Application No: AB/31/22/L

Site Address: Norfolk Arms Hotel 22 High Street Arundel BN18 9AB

Description of works: Listed building consent for EXTERNAL ALTERATIONS comprising minor change to proposed Entrance Lobby elevations from single doors to double doors (amendment to AB/23/16/L ). On side elevation to rear Courtyard removal of 1no. door & frame to existing Female Toilets & infill opening with white-painted masonry to match existing, to form 1 no. 'fake' window opening. First Floor side elevation (facing 20 High Street ) replacement of 1no. existing door height window assembly (to proposed Bedroom 3 ), with new timber-framed window, within existing opening. INTERNAL ALTERATIONS & CONVERSIONS comprising of: Ground Floor: re-positioning Reception closer to existing Hotel entrance, to replace existing 'Norfolk Bar', to form Dispense Bar & associated Store to replace existing Reception & Back-Office, conversion of 'Suffolk Room' & adjacent Female Toilets to form 1 No. Guest En-Suite Bedroom, conversion of existing Male Toilets & rear store to form Unisex Toilets facility, minor alterations within existing 'Old Kitchen' Dining Room to improve circulation for guests & staff, minor

**SIDE ELEVATION to COURTYARD
& ENTRANCE ARCHWAY (South-East)
PROPOSED 1:50.**

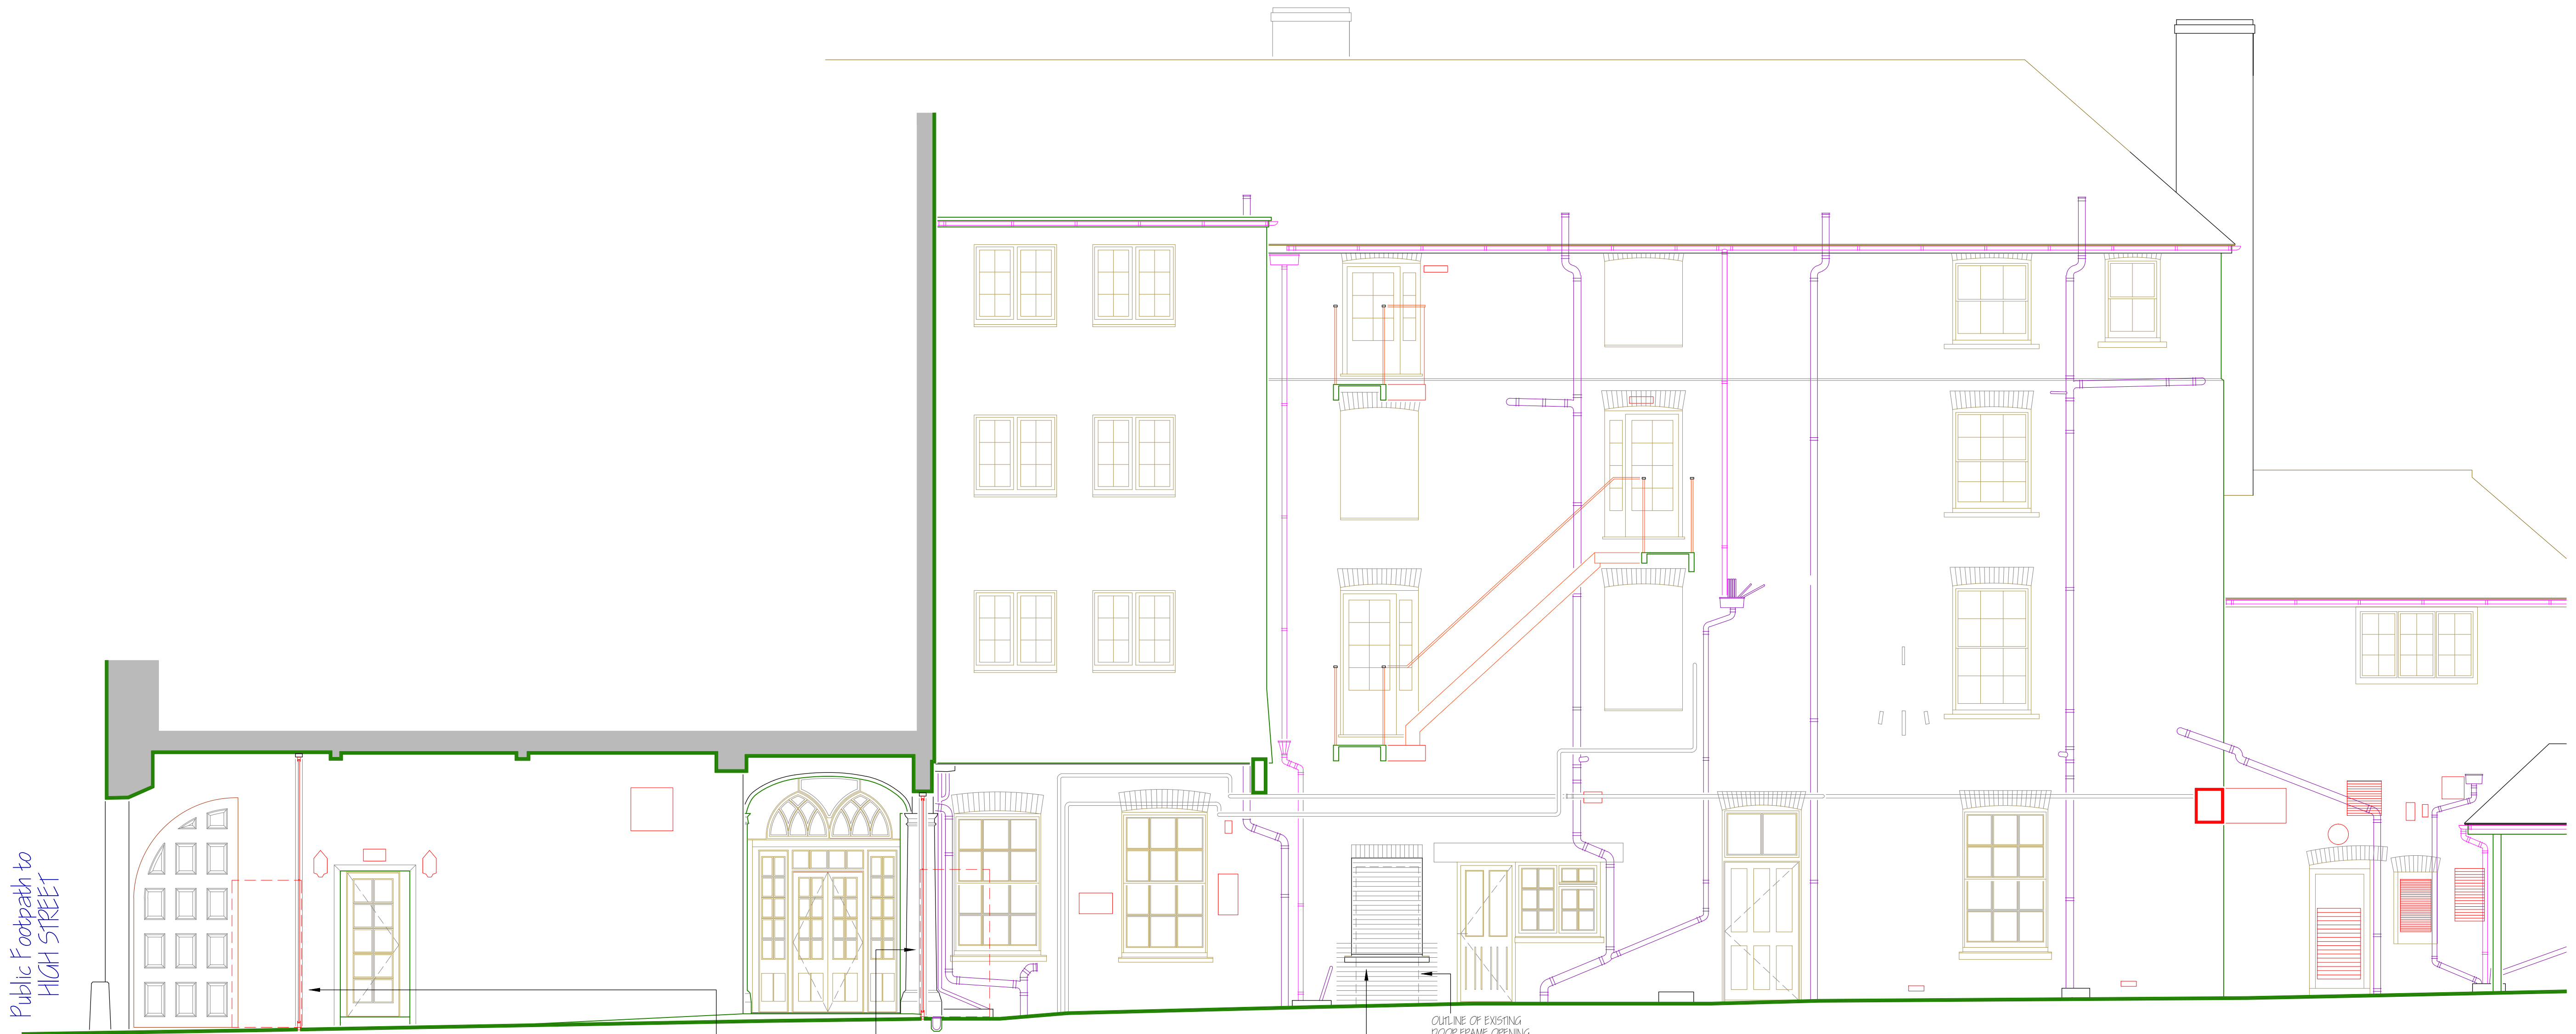
This is one of the most prominent buildings on the High Street and is Grade II\* listed. This imposes a responsibility on the local planning authority to weigh very carefully the impact of any proposals for alterations. There is reference in the application documents to a previous approval in April 2016 for the introduction of glazed screens to enclose the area beneath the archway. Presumably this consent has now expired and the details and impact of these proposals must be considered afresh as part of the current application. Given the

historic significance of the building and the importance and purpose of the archway in relation to the original use of the building as a coaching inn, I object to the principle of enclosing the space beneath it. This would adversely impact the building and detract from its unique appearance in the street scene and adversely affect the character of the conservation area - thus failing to meet the "protect or enhance" test.

Should the planning authority be minded to recommend approval of the proposals for the glazed screens then a condition should be imposed requiring the use of frameless glazing to minimise the impact and harm on the building itself and the conservation area.
